Our Ref: BN/35/14/L

**Planning (Listed Buildings and Conservation Areas) Act 1990 (as amended)
Planning (Listed Buildings and Conservation Areas) Regulations 1990 (as amended)
Application for Listed Building Consent**

Development Application for listed building consent for the construction of rear single storey garden room extension.
Location Barnham Court Lodge Church Lane Barnham

| Block Plan as Existing                                                      |         |         |                       | DRAWING NUMBER                      |                       |          |  |

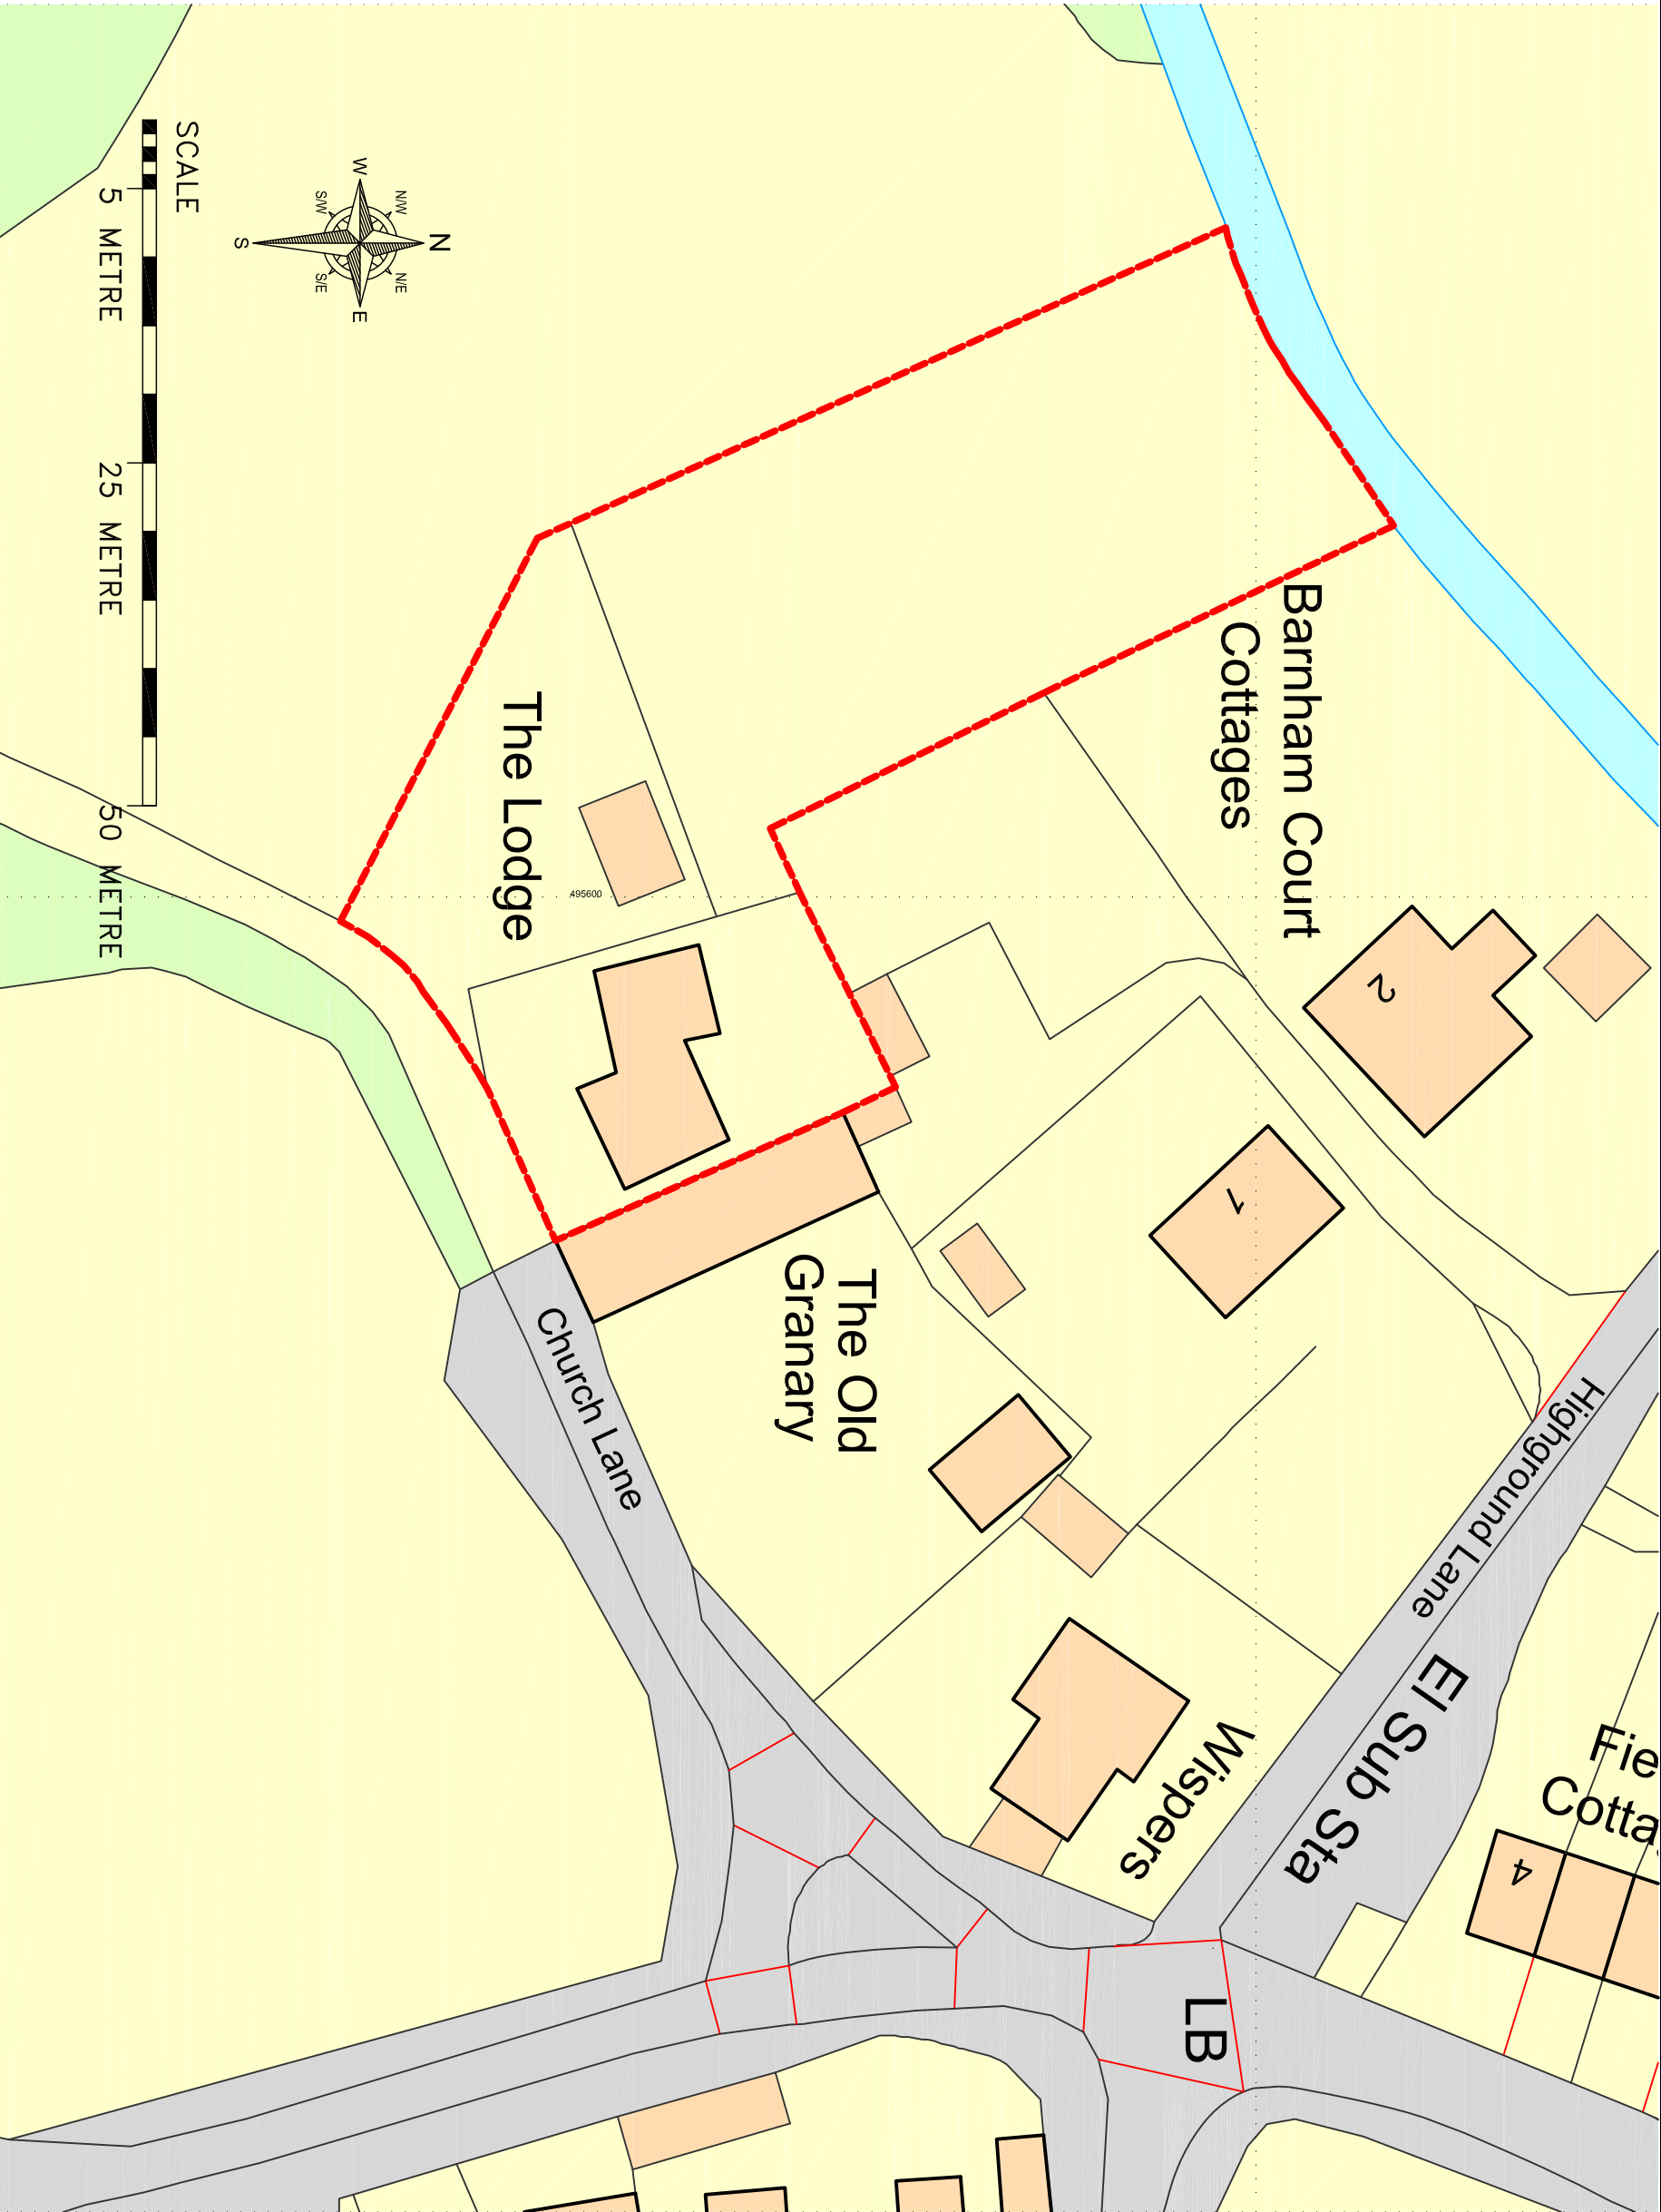
Block Plan

Please submit 1 electronic or 3 paper copies of a block/site plan at a scale of 1:500 or 1:200. Further details of what must be included on the plan can be found in the National Validation Requirements. Please provide measurements from the proposal to the site boundaries.
